**CITY OF ALBUQUERQUE
PLANNING DEPARTMENT
July 18, 2012
DRB Comments**

ITEM # 12

PROJECT # 1009334

RE: Lots A & B1, Campbell Addition No. 1

**Boundary Survey  
and  
ALTA/ACSM Land Title Survey  
for  
Lots Lettered "A" and "B-1"  
Campbell's Addition No. 1  
City of Albuquerque  
Bernalillo County, New Mexico  
April 2012**

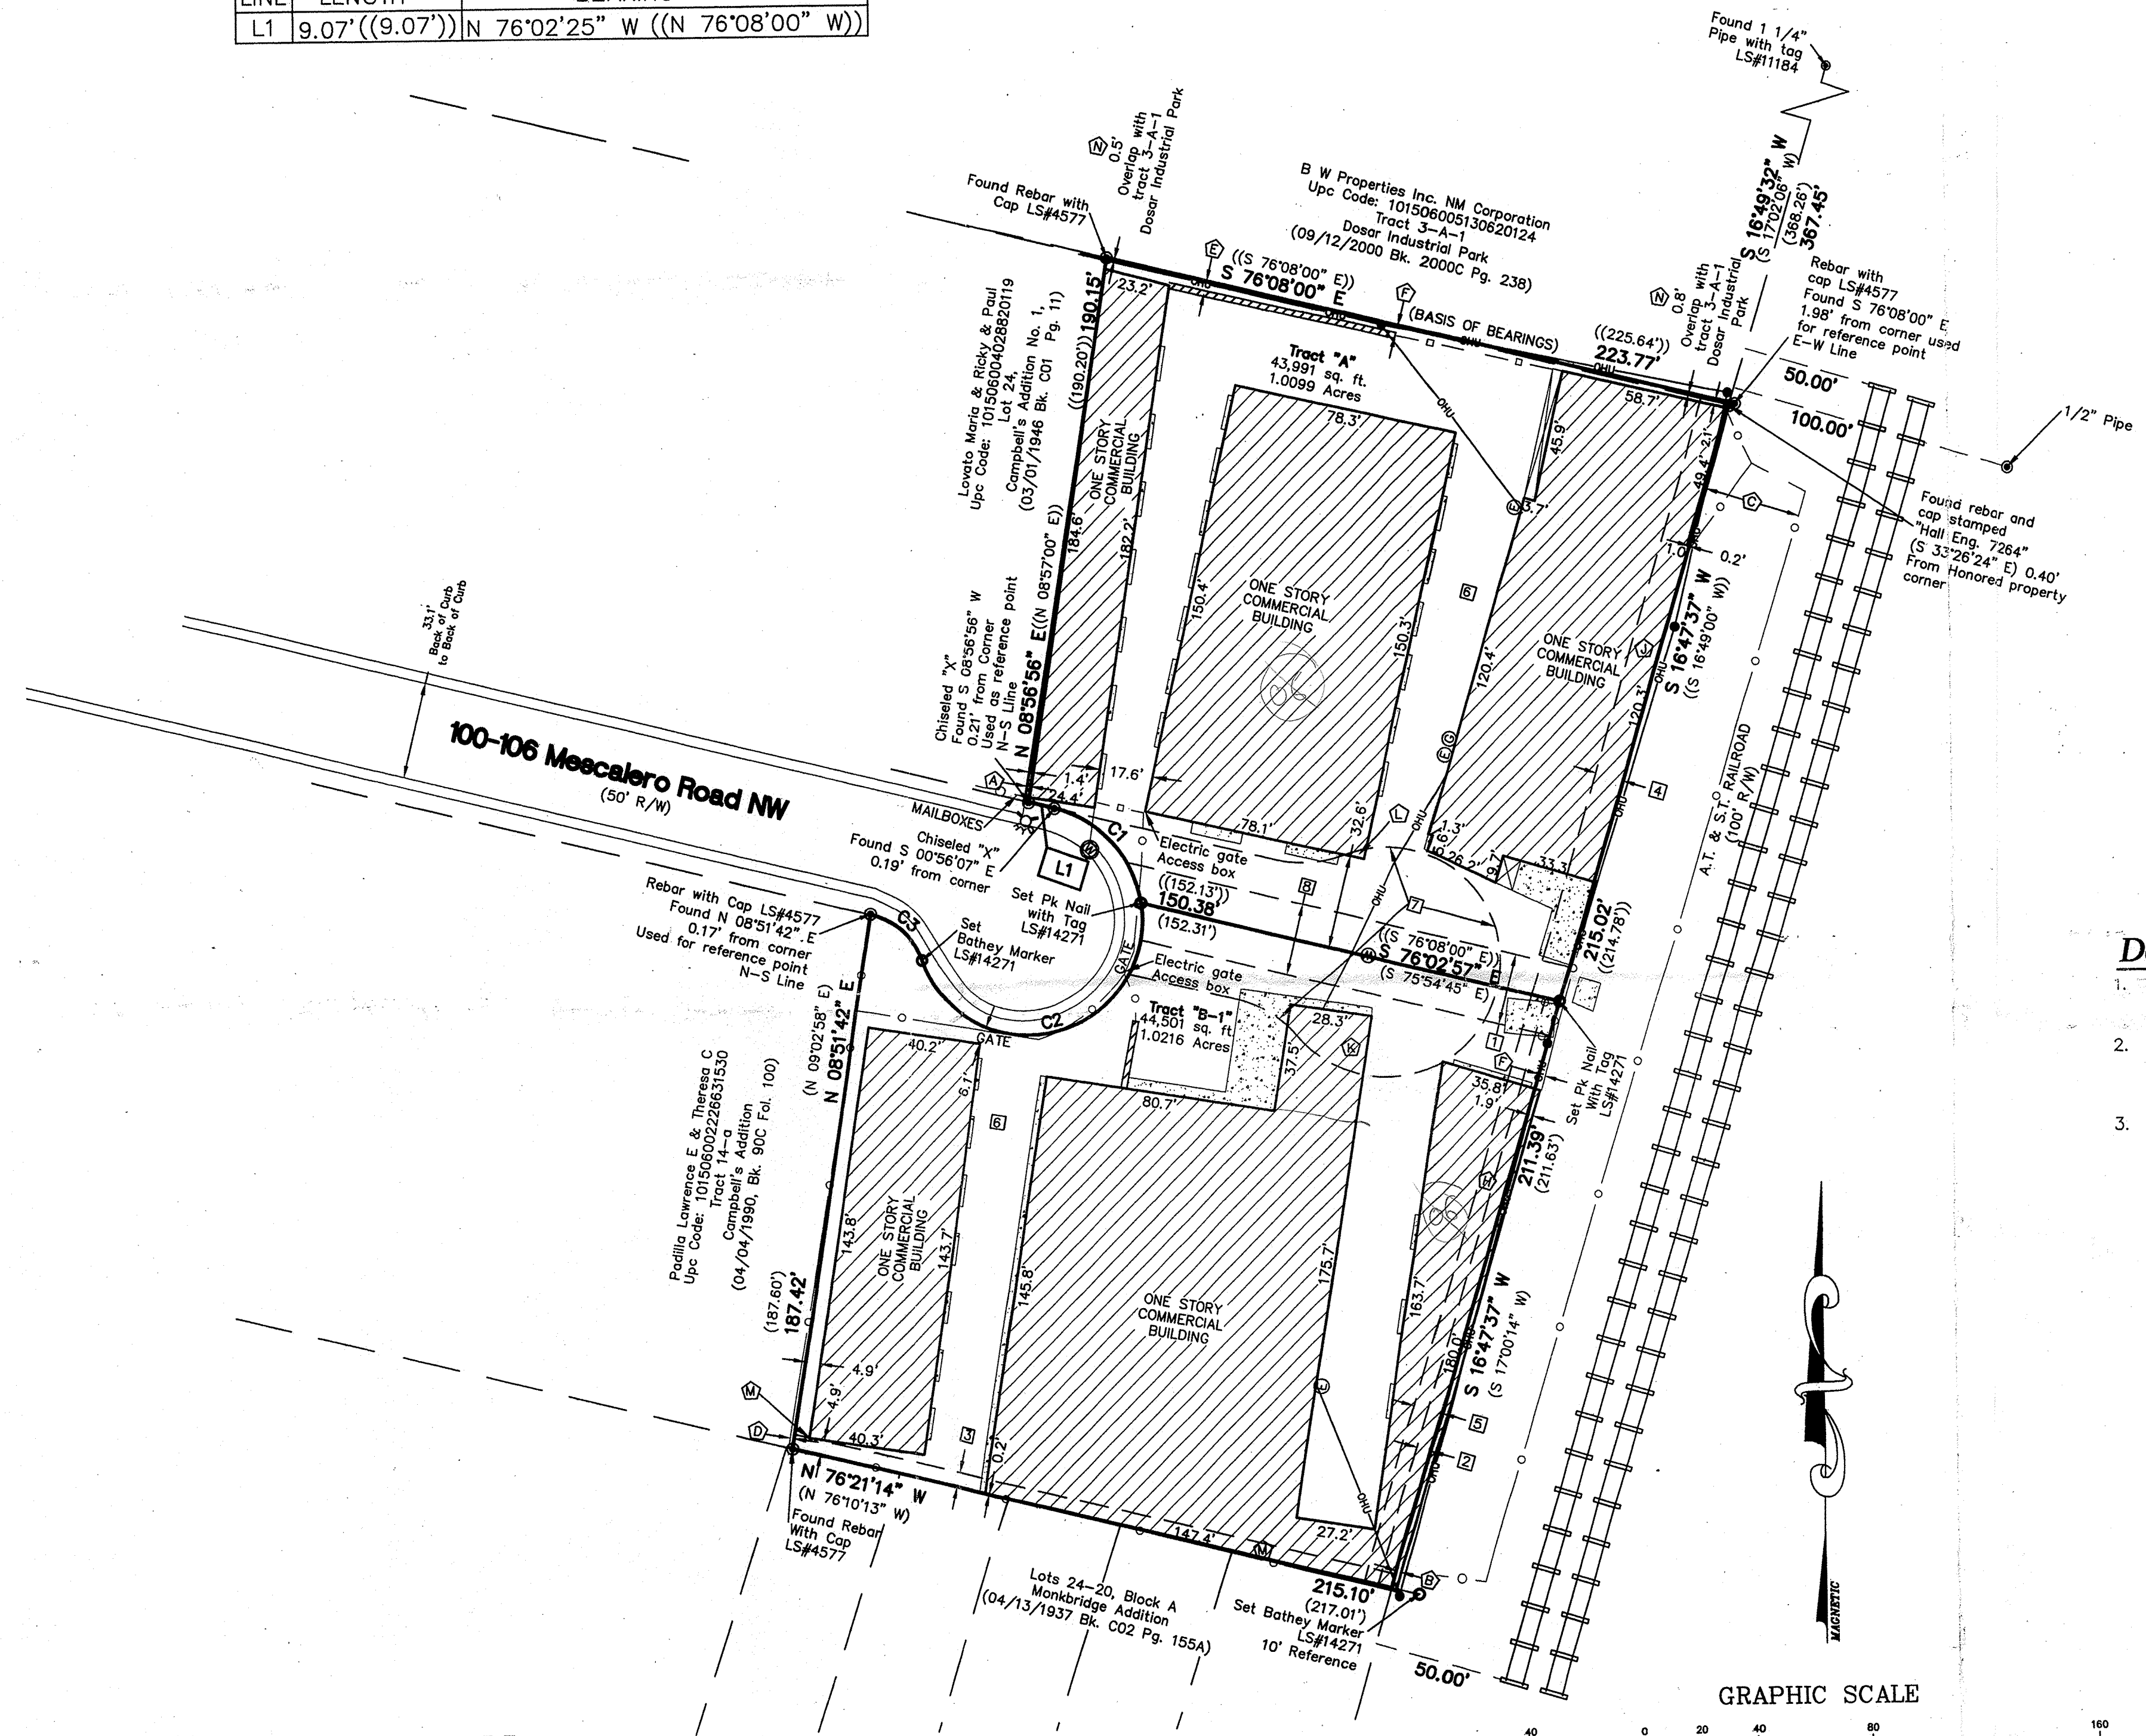
Please provide copies of latest plats (1976 and 2004) - retained easement(s) that were shown on the plat(s) would require a vacation application, with an advertised public hearing by the DRB and a fee of \$140. If none of the easement users object and if the vacation is approved, the lots would have to be replatted by a surveyor licensed in New Mexico within one year in order to complete the vacation; the fee for a two lot subdivision would be \$305.

Encroachments would need to be corrected and conformance with the Zoning Code (setbacks, parking etc.) would have to be demonstrated at the time of subdivision, or variance(s) would be required.
